PORTLAND MAINE

MEMORANDUM

DATE: August 28, 2012

SUBJECT: Canal Landing/New Yard LLC: Comments on Conditions of Approval Compliance

DRAWN: CMW DATE: APR 2012  
 DESIGNED: RJW SCALE: 1" = 50'  
 CHECKED: SRB JOB NO. 3091  
 FILE NAME: 3091-SITE LAYOUT  
 SHEET: C-2.1

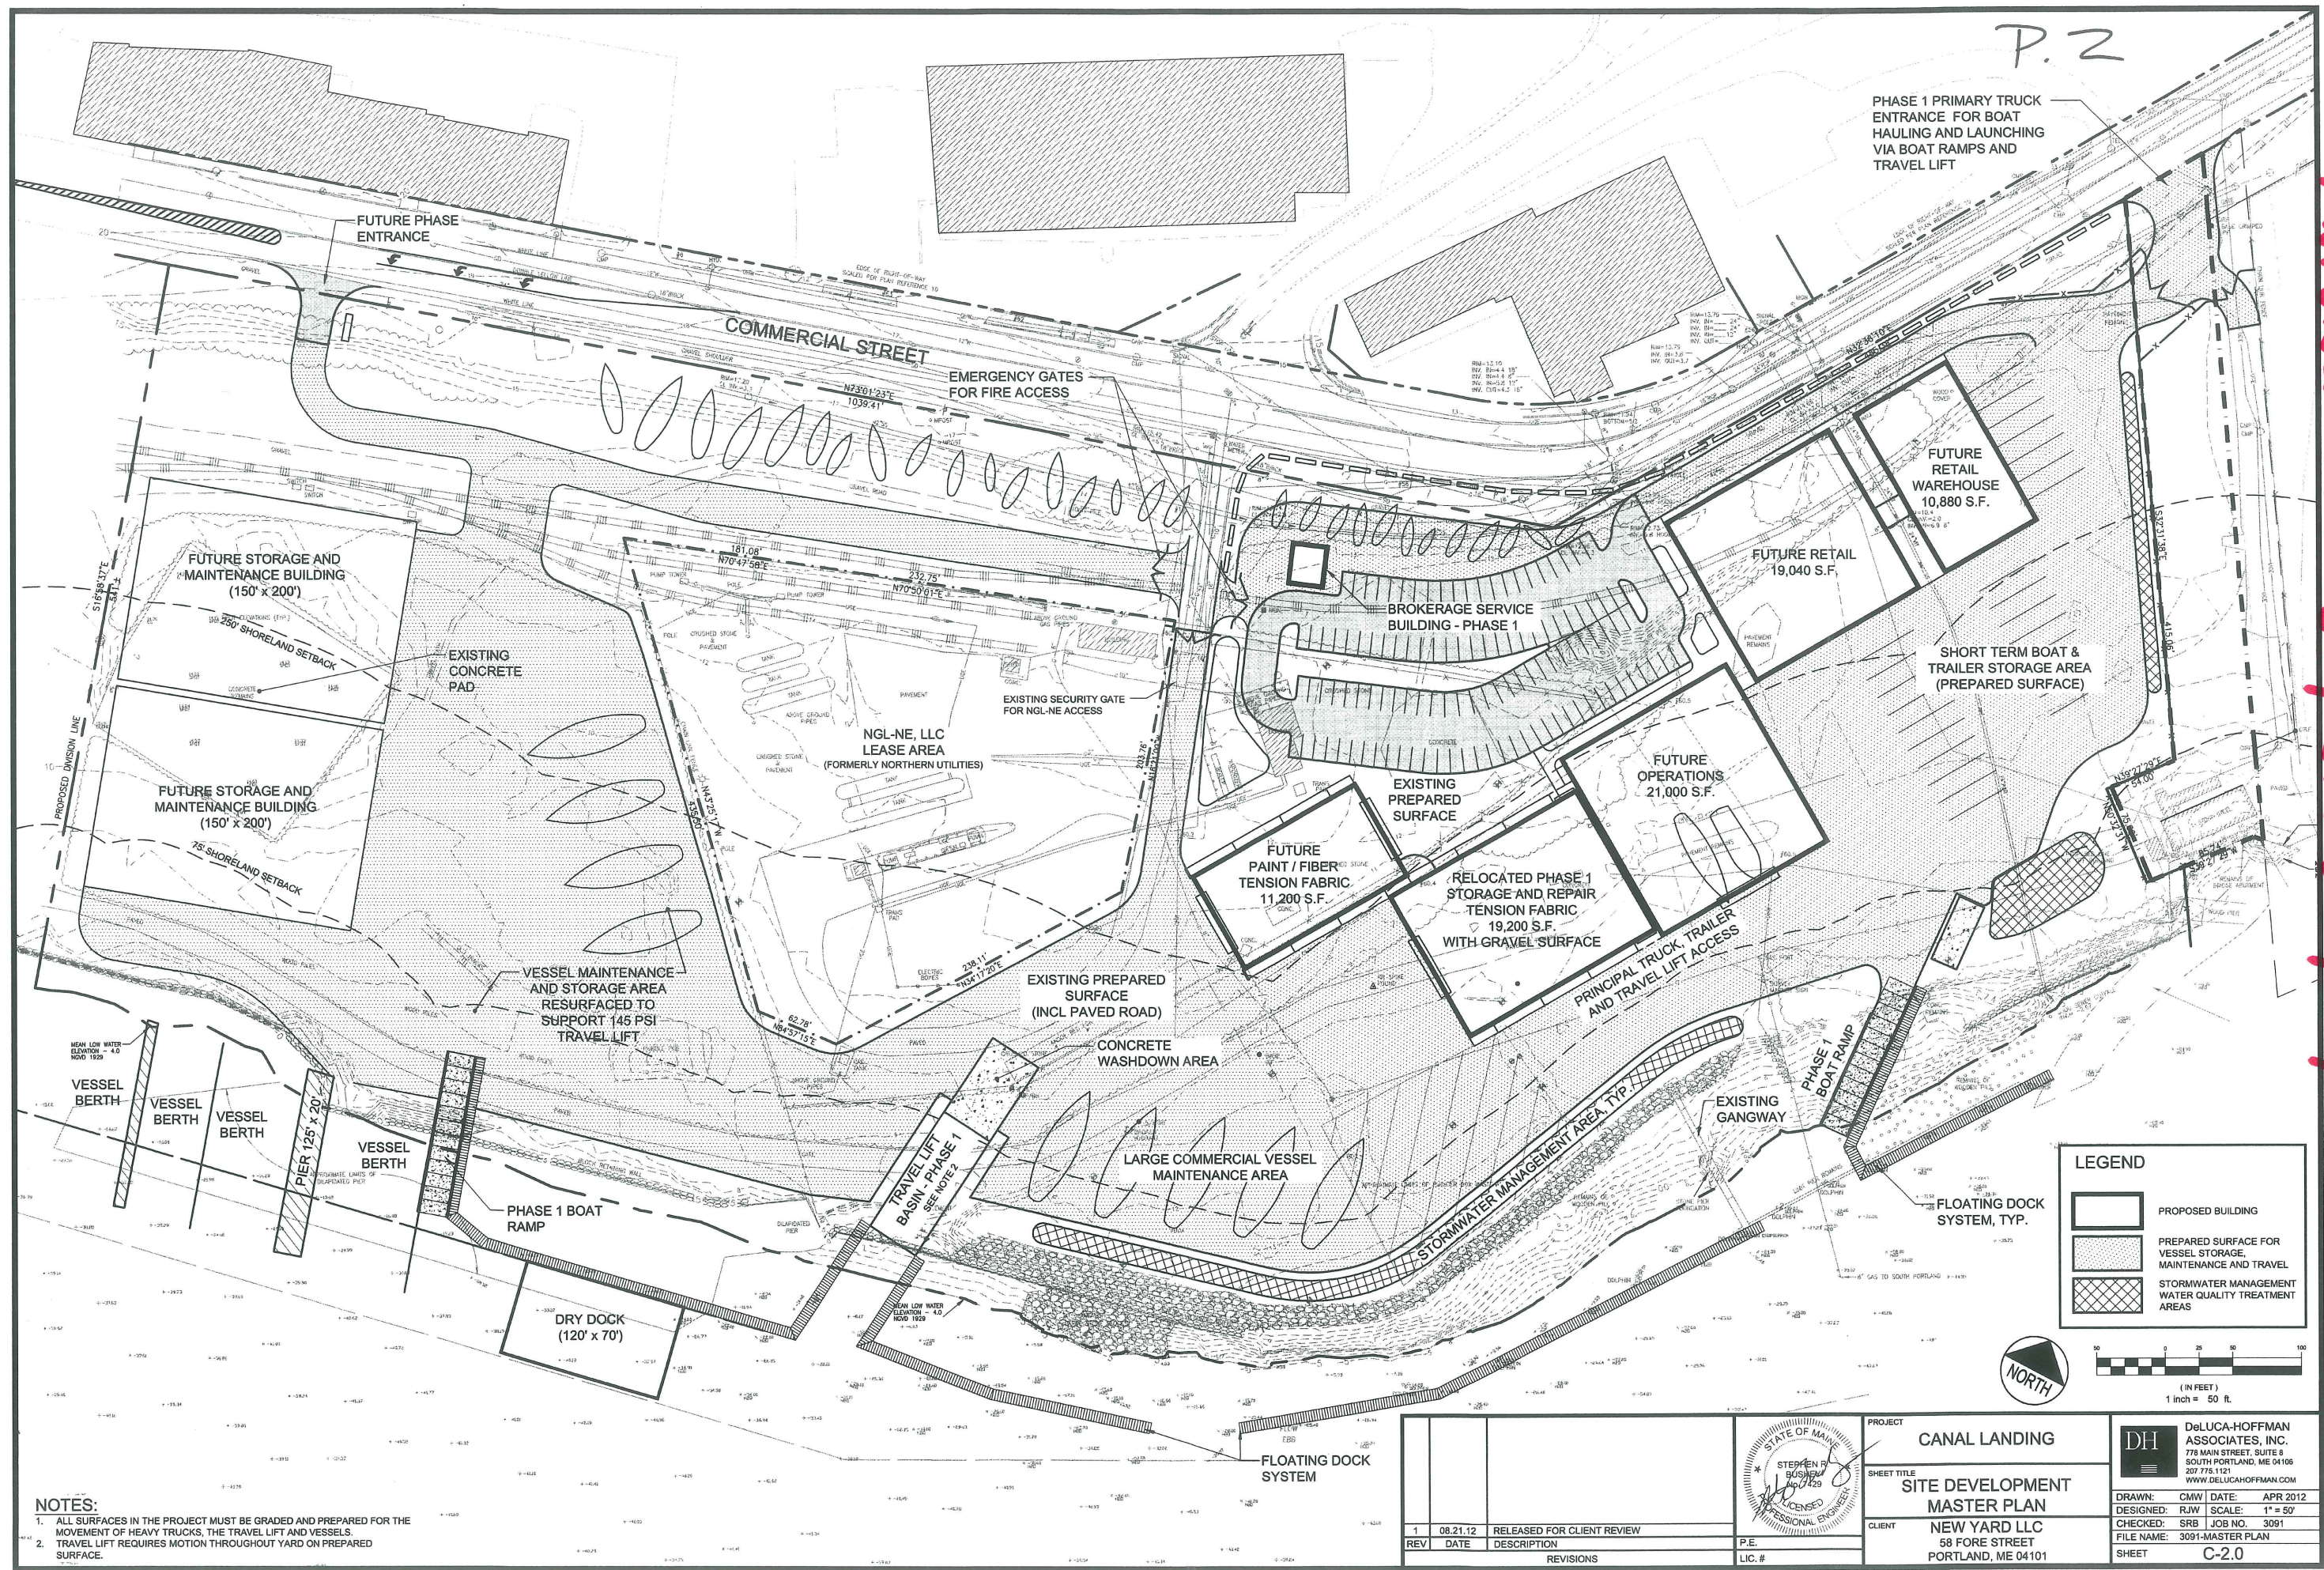
iii. Combined Sewer Overflow Easement: that prior to issuance of a building permit, the applicant provides a 30 foot wide easement to the City for the combined sewer overflow line crossing the property from West Commercial Street to the Fore River as shown on the Deluca Hoffaman Site Development Plan, C-2.1, revision 4, dated 12-5-12.

Since Phase 1a needs to stand on its own, Public Services needs the easement in conjunction with the first phase of development.

PROJECT: CANAL LANDING (PHASE 1A)  
 TITLE: FIRE PROTECTION PLAN PHASE 1A ONLY  
 CLIENT: NEW YARD LLC  
 58 FORE STREET  
 PORTLAND, ME 04101

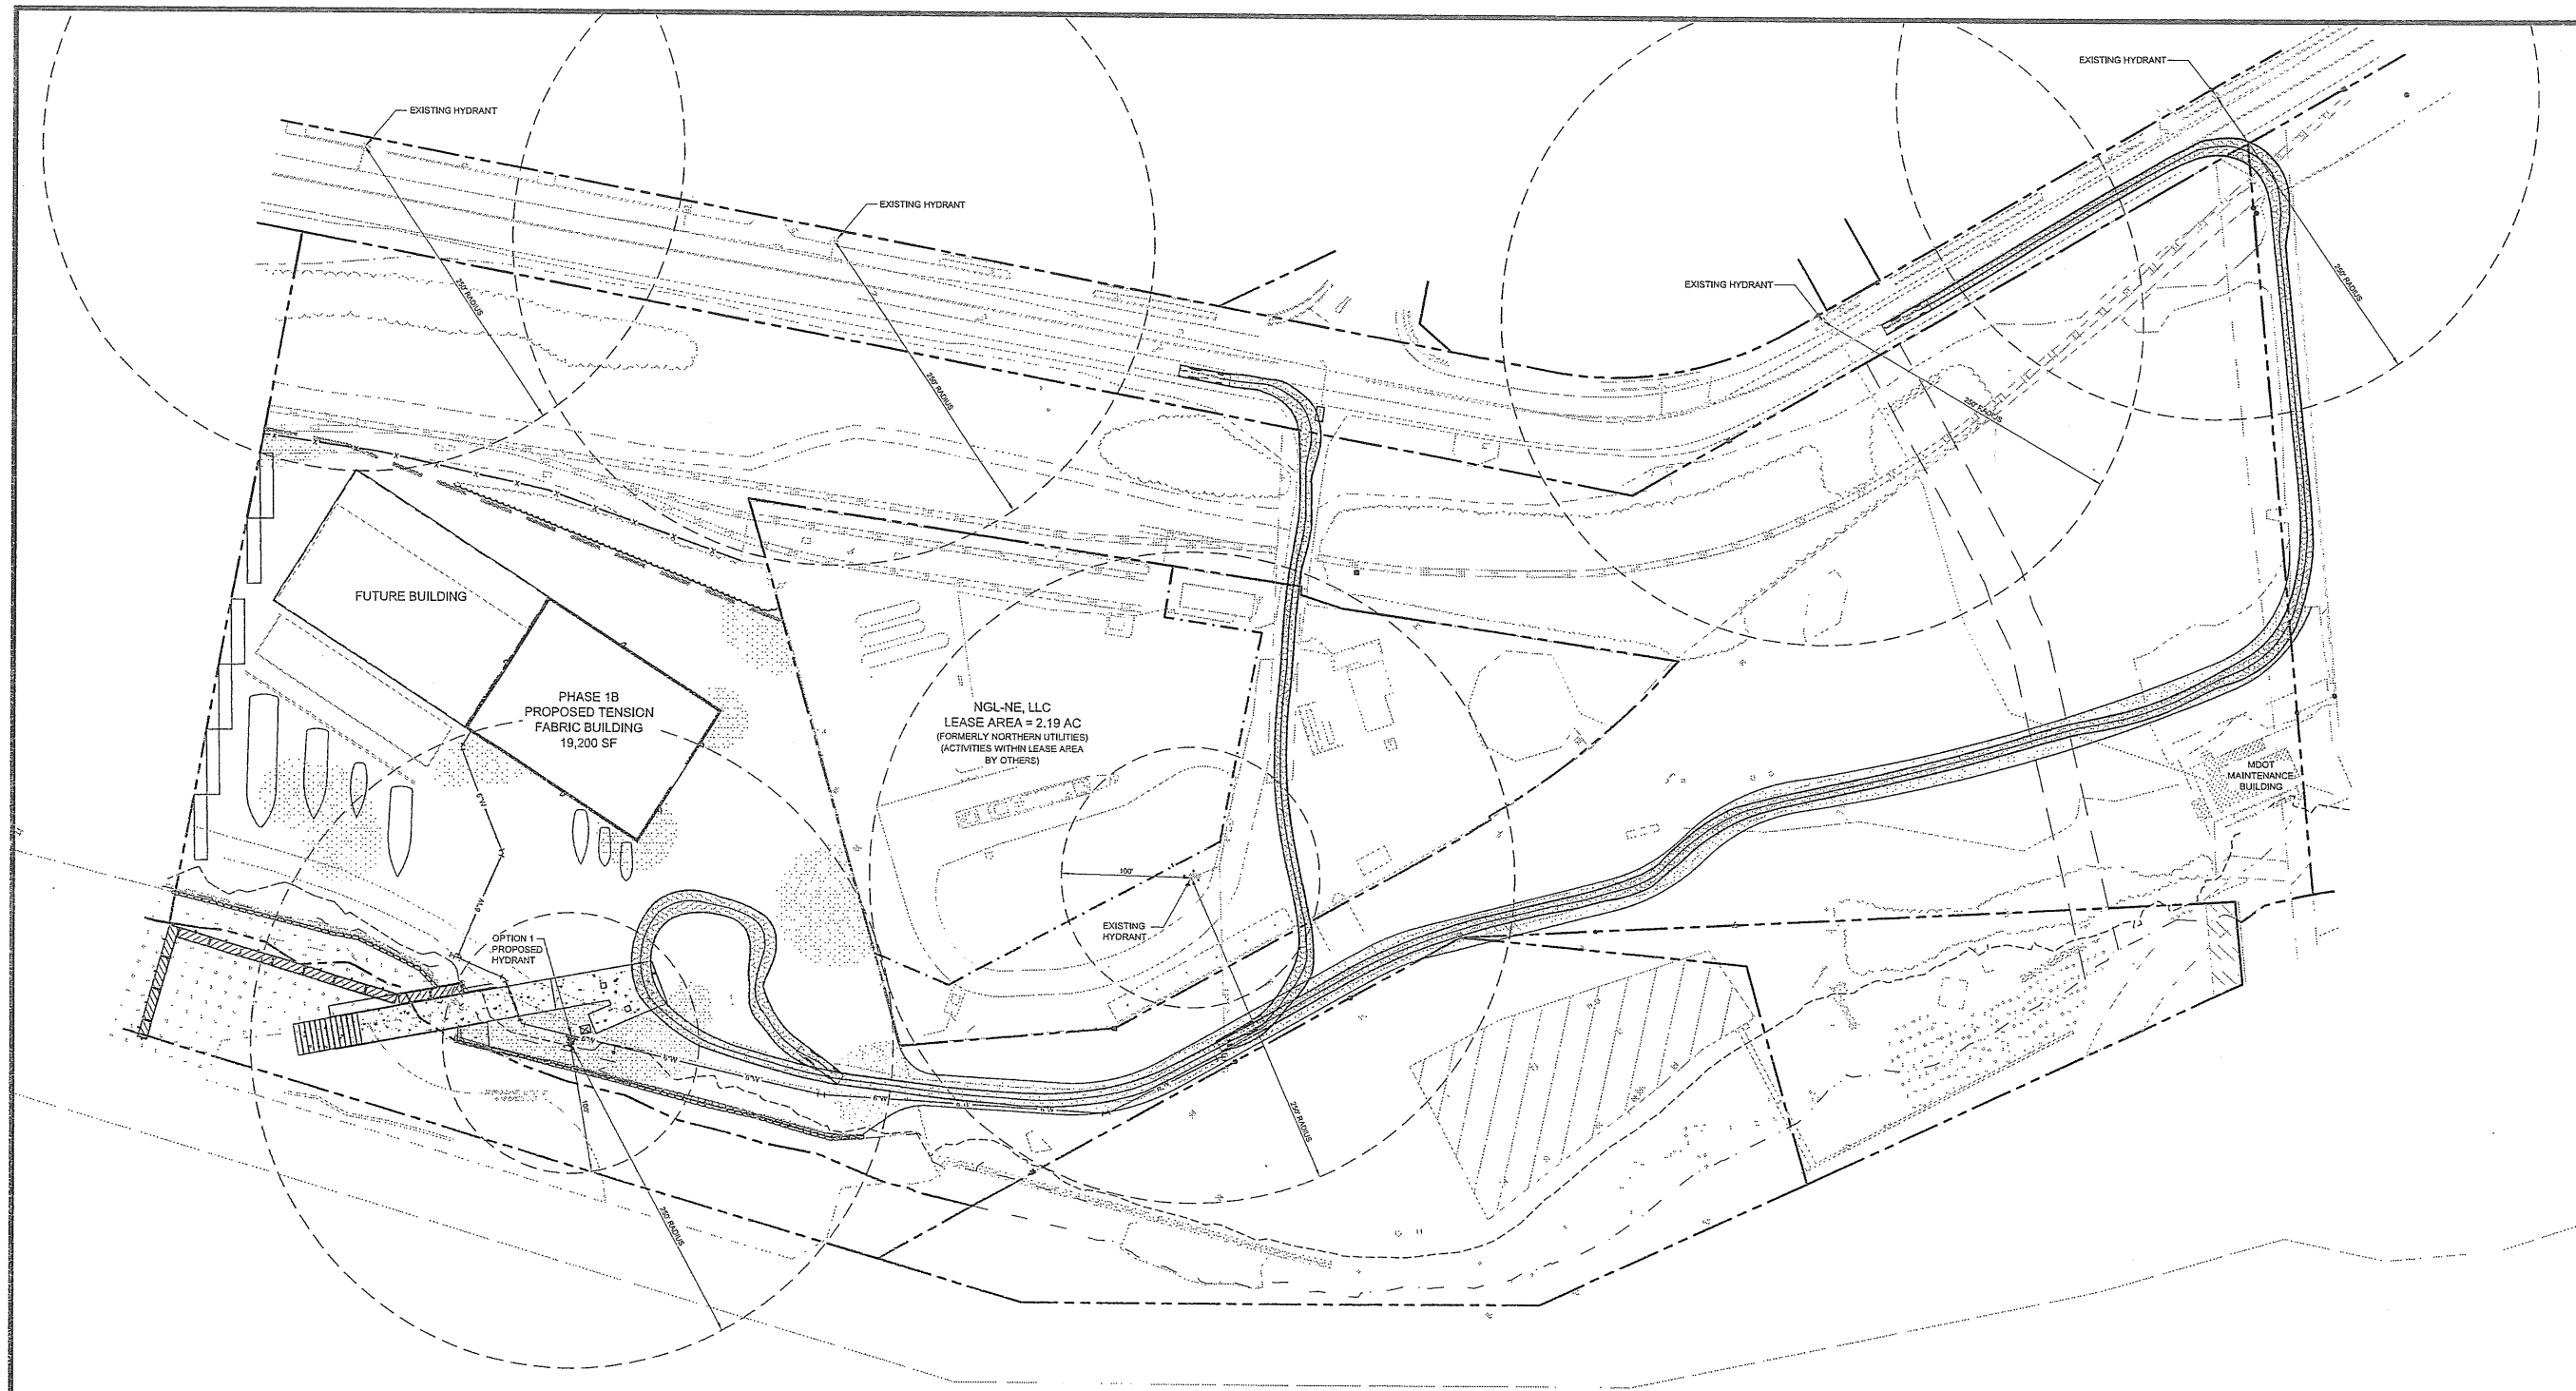
viii. Fire Safety and Emergency Access: that prior to issuance of a building permit, the applicant submit a revised site plan for review and approval in compliance with the December 12, 2012 fire code analysis memo from Fire Risk Management, Inc. (Attachment U of Planning Report #53-12) The revised site plan will show emergency access routes to be kept clear of stored and trailered vessels, vehicle parking and snow storage.

As required in the August 27 amendment approval, I know that you are working on the revised Fire Safety Plan based on the 1a build out.
